MEMO

TO: Nell Donaldson
FROM: Mike Farmer
DATE: April 7, 2015
RE: 195 Kennebec Street – site plan review

PRELIMINARY - NOT FOR CONSTRUCTION

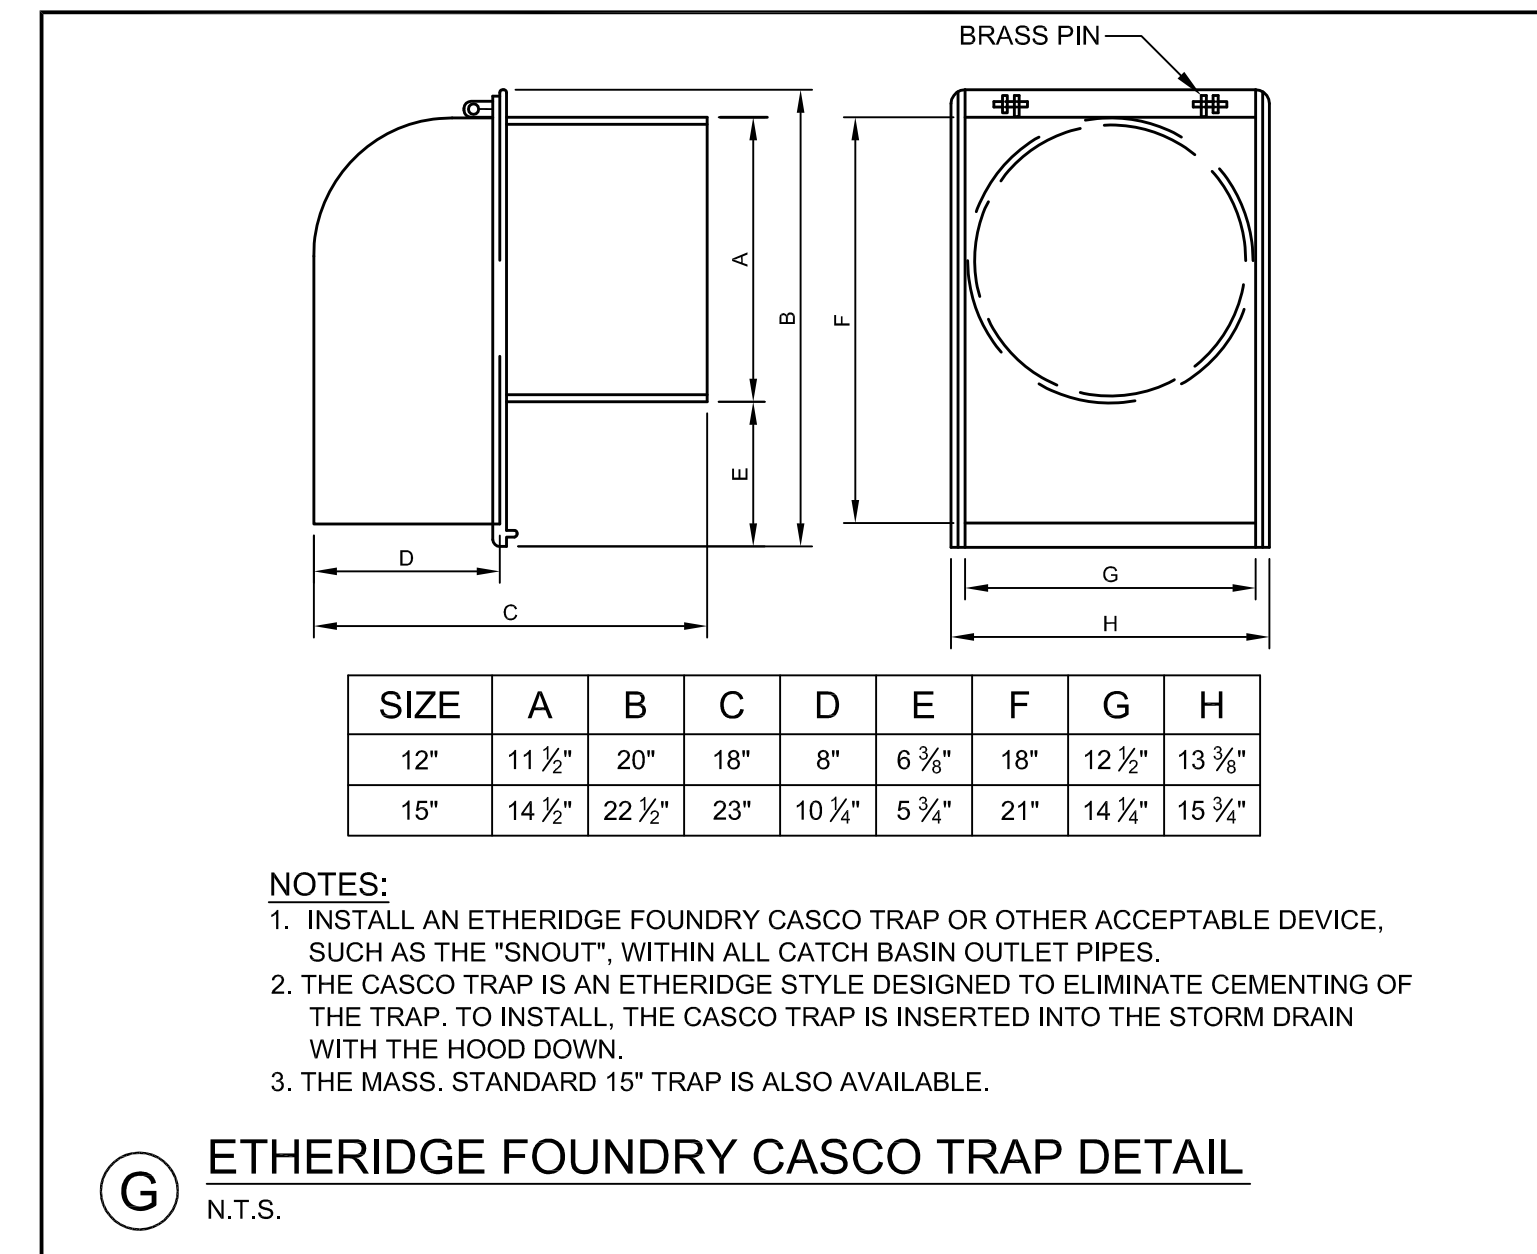
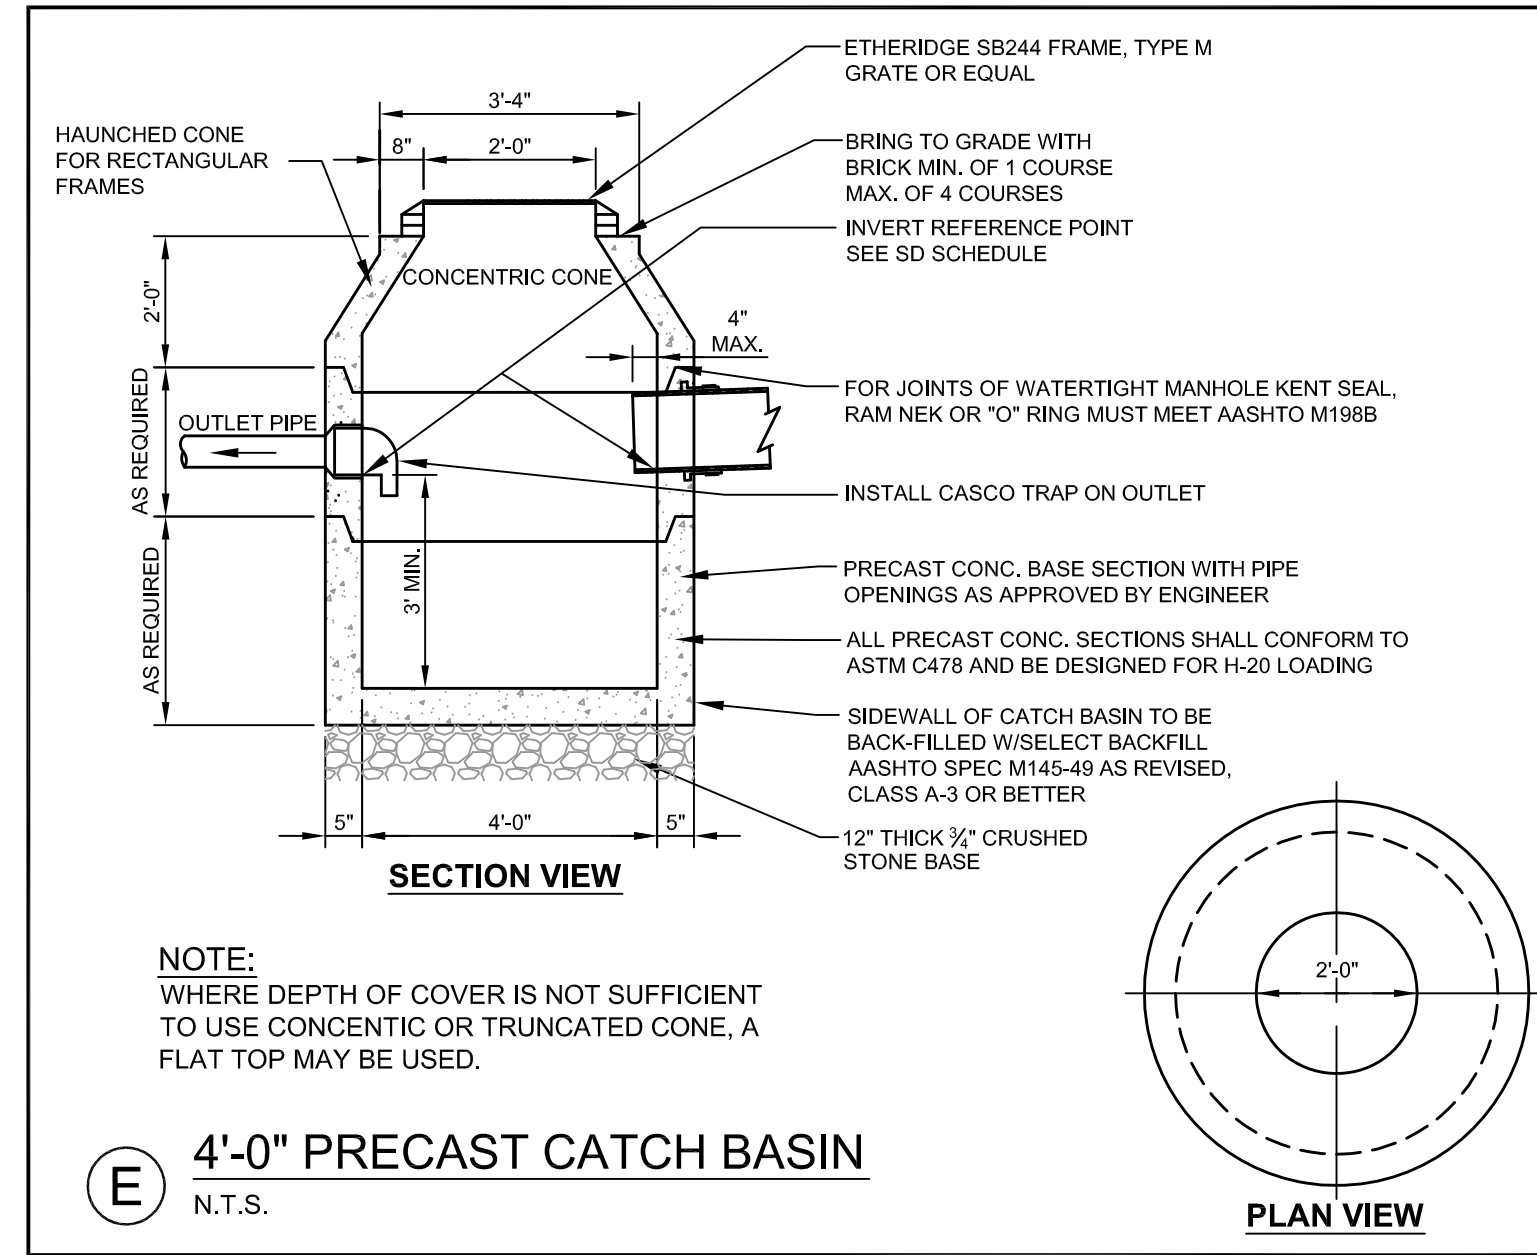
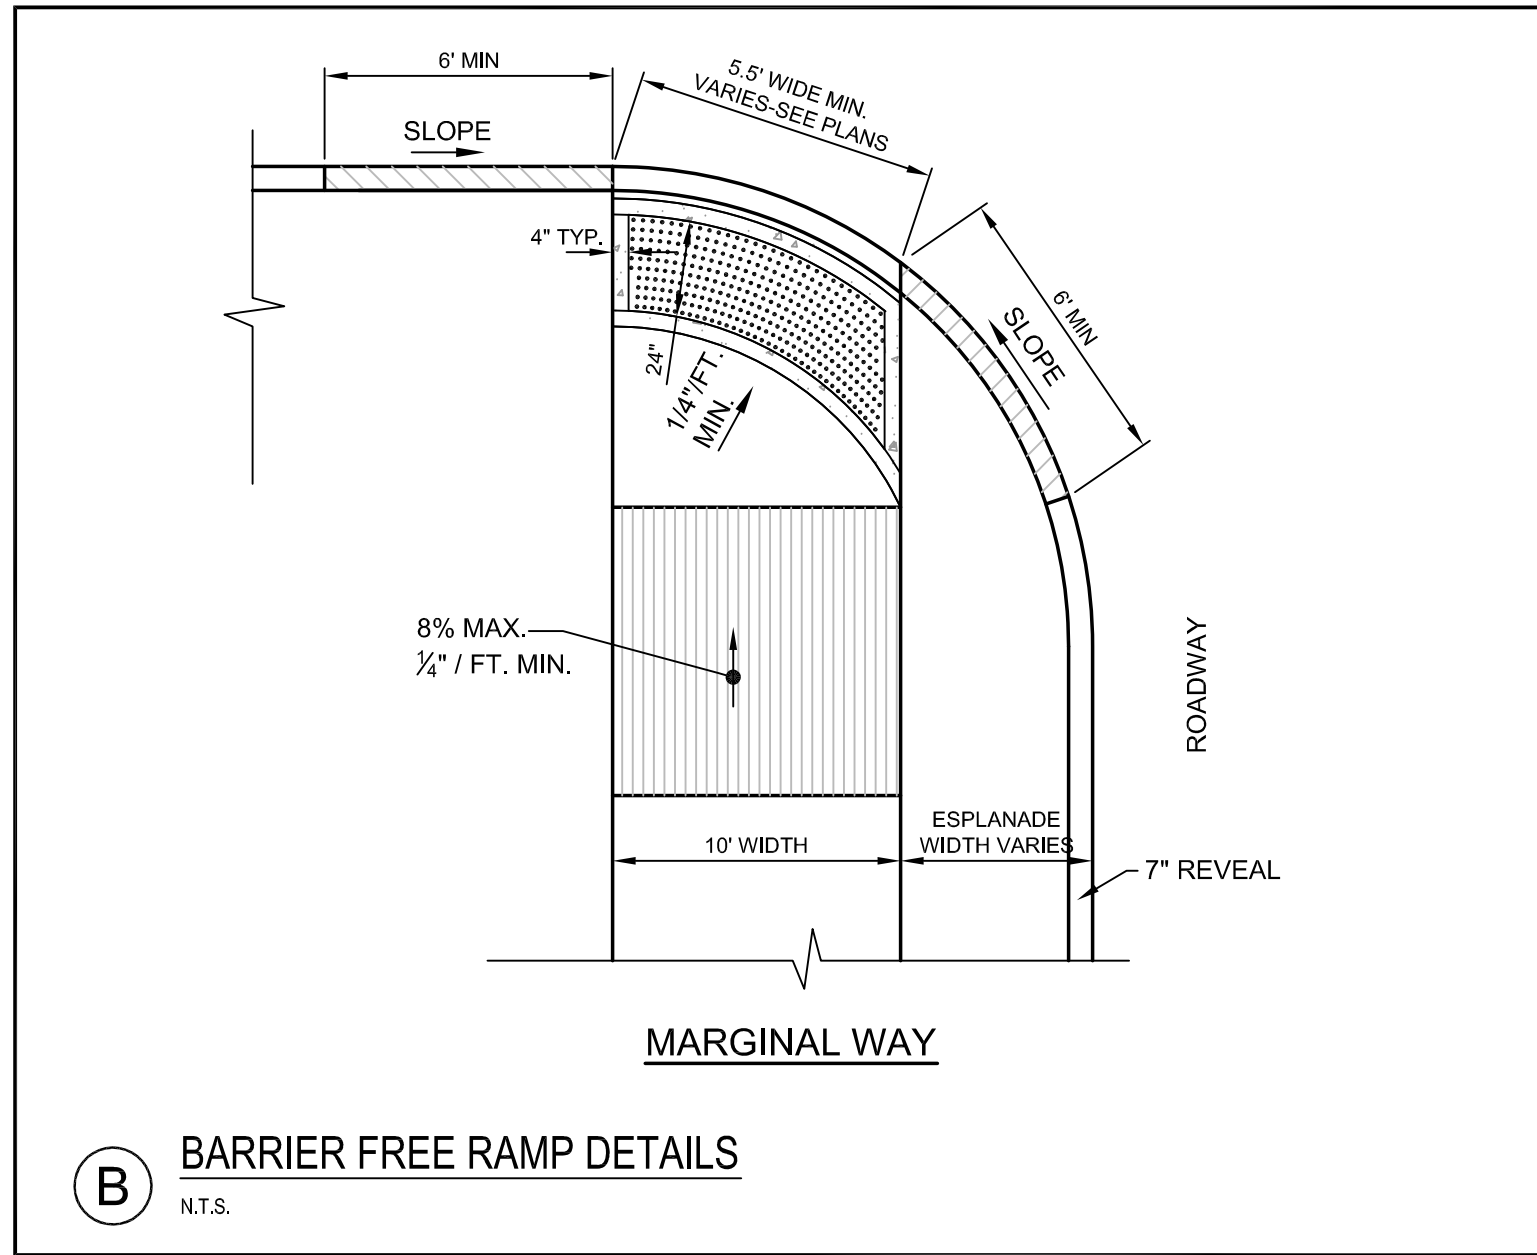
Detail A on plan sheet C-7.1 shows a curb reveal of 6 inches along Kennebec Street. The City standard for curb reveal is typically 7 inches. The curb reveal should be changed to match the City standard unless there are over-riding considerations that require a 6 inch curb reveal. A change to 6 inch curb reveal may require changing the specification for granite curb terminal pieces from 6 feet to 7 feet in length.
